Recommendation Report for Planning Permission for Works or Extension to a Dwelling

REF NO: LU/311/15/HH

LOCATION: 6 Carvel Way
Littlehampton

PROPOSAL: Single storey rear extension & first floor side extension over garage. This application may be determined by Littlehampton Town Council under delegated powers. (Resubmission following LU/161/15/HH).

1st FLOOR PLAN

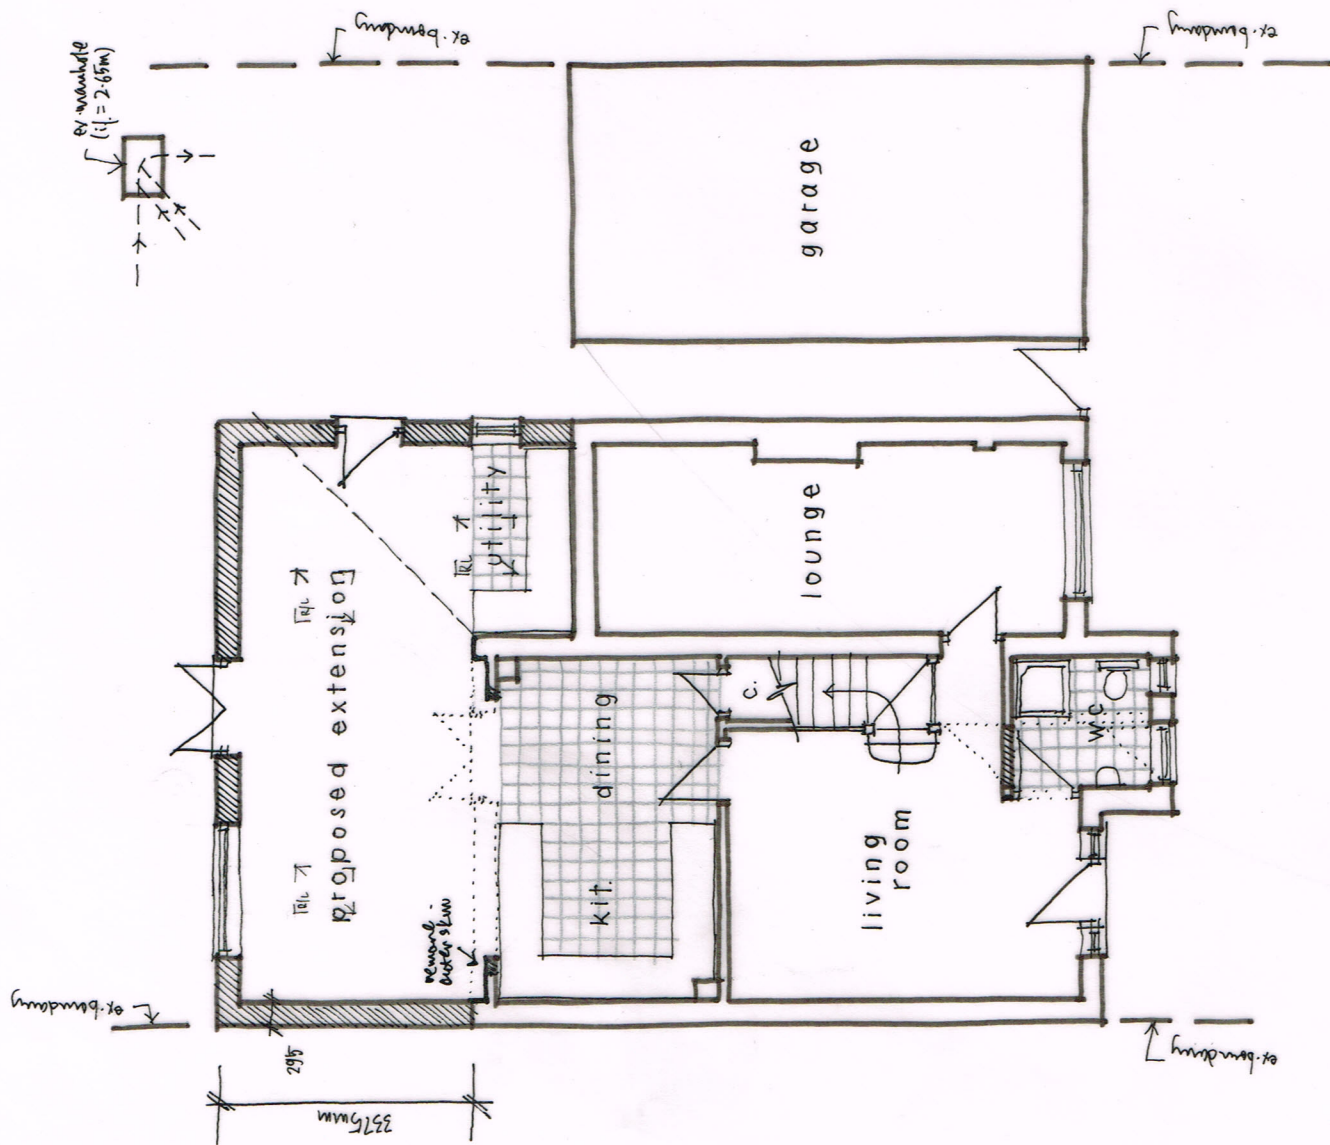
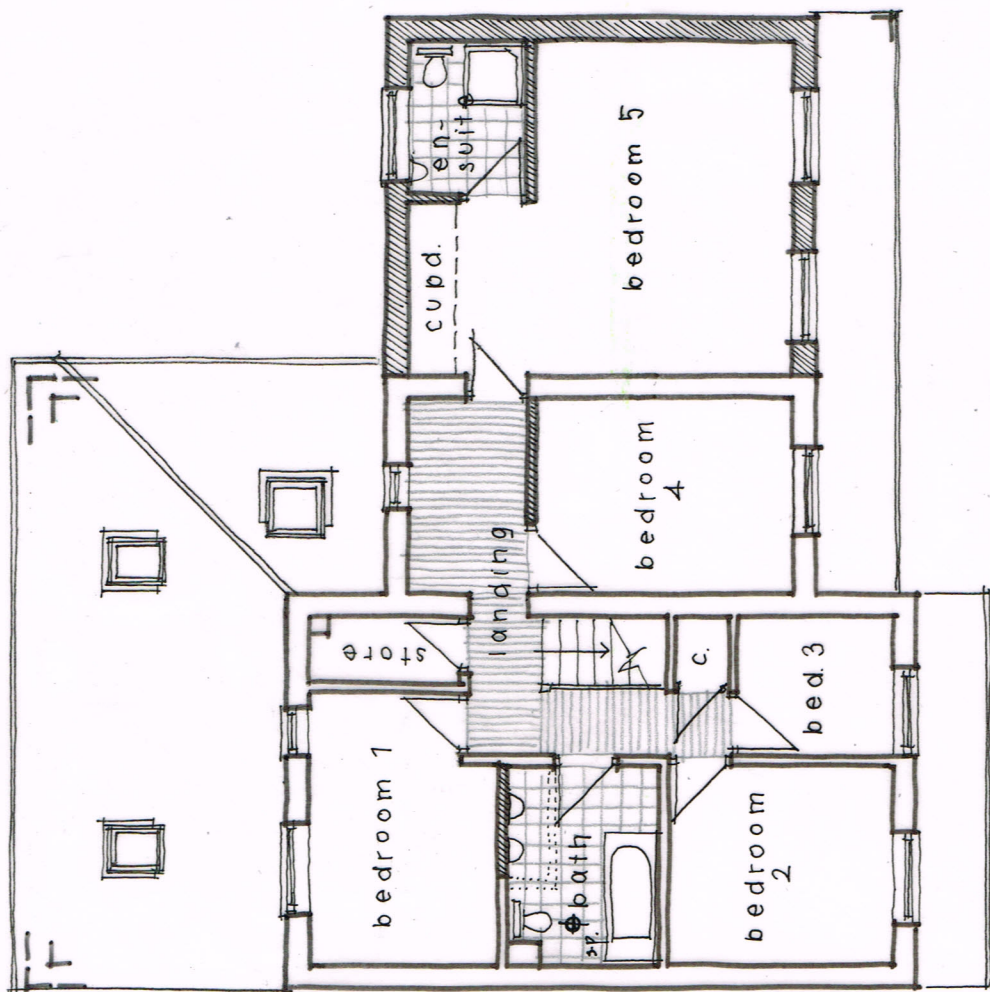
The proposed single storey rear extension will extend a maximum of 4.7 metres from the rear wall of the original dwelling house with the existing conservatory to be removed. It will have a height of 3.7 metres with a mono-pitched roof. This aspect of the proposal is considered to appear well integrated and subservient to the host dwelling in accordance with policies GEN7(ii) and DEV19 (i) & (ii) of the Arun District Local Plan.

The proposed first floor extension will be located above the existing garage extending 4.7m to the

PROPOSED ELEVATIONS 1:100@A3

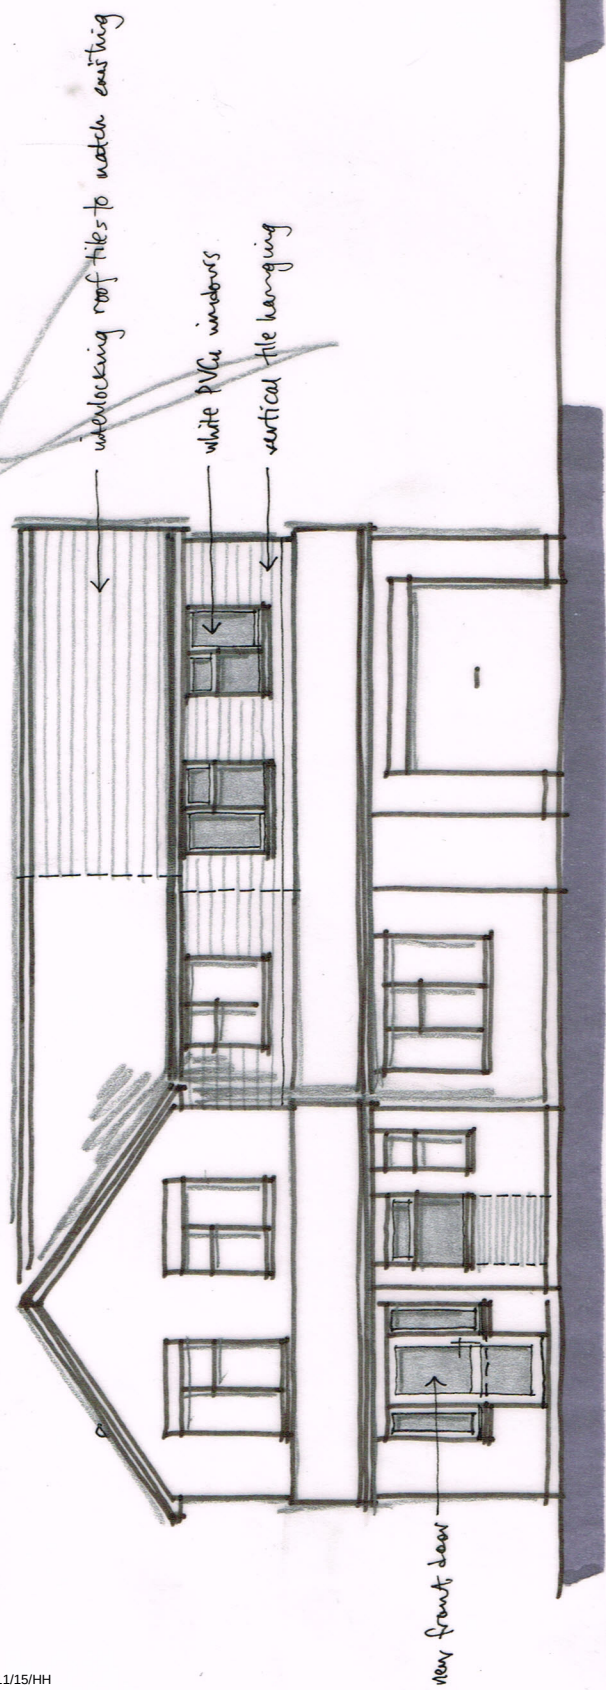
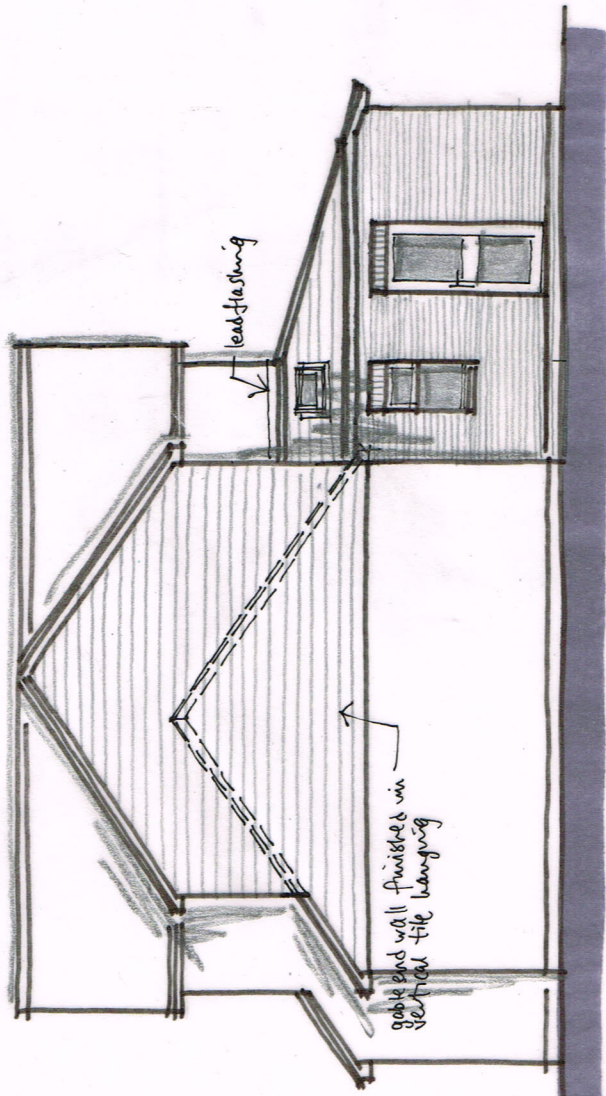
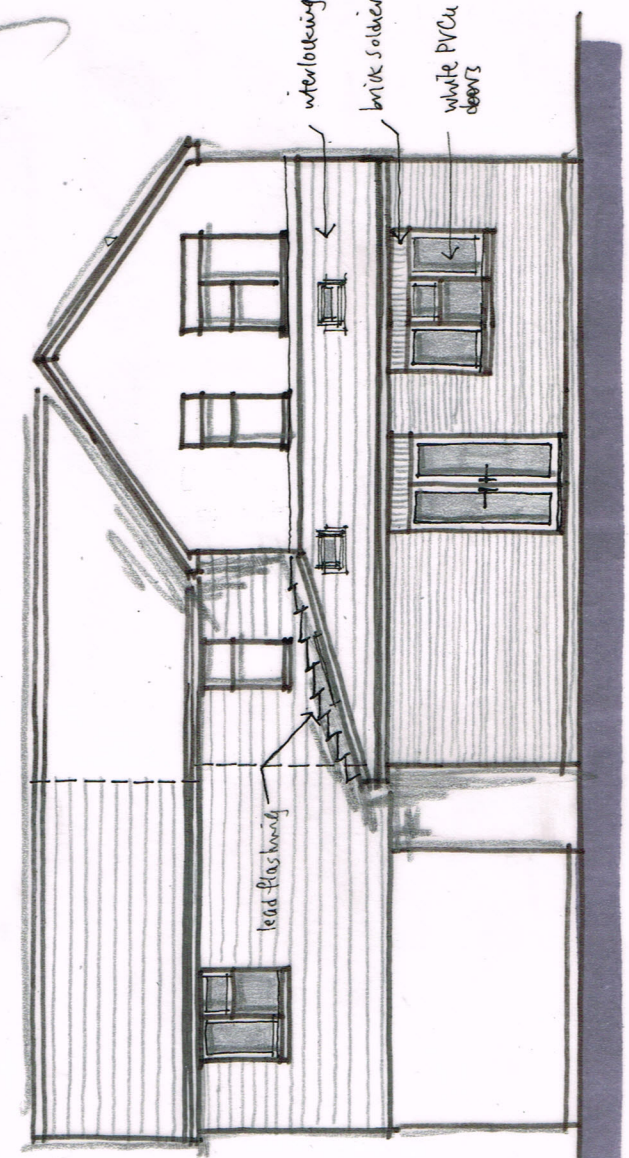
east of the existing first floor. It will measure 7.1m above ground floor and will feature a roof which will match the existing ridge height and roof slope of the previously approved first floor extension under reference LU/275/99. The proposed extension is shown as being tile hung and this is considered detrimental to its appearance within the street scene, with the proposed materials failing to ensure that the proposal appears integrated with the host dwelling in accordance with policy DEV19 (i) of the Arun District Local Plan. Tile hanging is also not a feature of this area and as such the proposed use of tile hanging is considered to be out of keeping with the area and therefore in conflict with policy GEN7(ii). Suitable materials could be secured by way of a condition on approval.

The proposed first floor extension is not considered to be in keeping with the wider character and appearance of the area - 6,8 and 10 Carvel Way were originally a row of three link-detached properties of the same design. The earlier approval under reference LU/275/99 gave permission for the conversion of the existing garage, construction of a new attached garage and the construction of a first floor side extension. This latest application seeks to add an additional 4.7m first floor extension above the garage which is considered to have an unacceptable impact upon the appearance of the host dwelling and the character and appearance of the wider area.

Carvel Way and this estate features semi-detached and terraced properties of a similar design, size and style but the proposed alteration will result in 6 Carvel Way measuring 12.2m in width at first floor level in comparison to 8 and 10 which have a width of 5.1m at first floor level.

Therefore, the proposed alterations would result in a dwelling of a size and style which would appear incongruous and detrimental to the character of the locality in conflict with policy GEN7(ii) and DEV19(i), (ii) & (iv) of the Arun District Local Plan.

- 1 The proposed first floor extension due to its choice of materials, significant size and prominent location is considered to have an unacceptable incongruous impact upon the character and appearance of the host dwelling as well as the character of the wider locality in conflict with policies GEN7(ii) and DEV19 (i), (ii) & (iv) of the Arun District Local Plan and the National Planning Policy Framework.
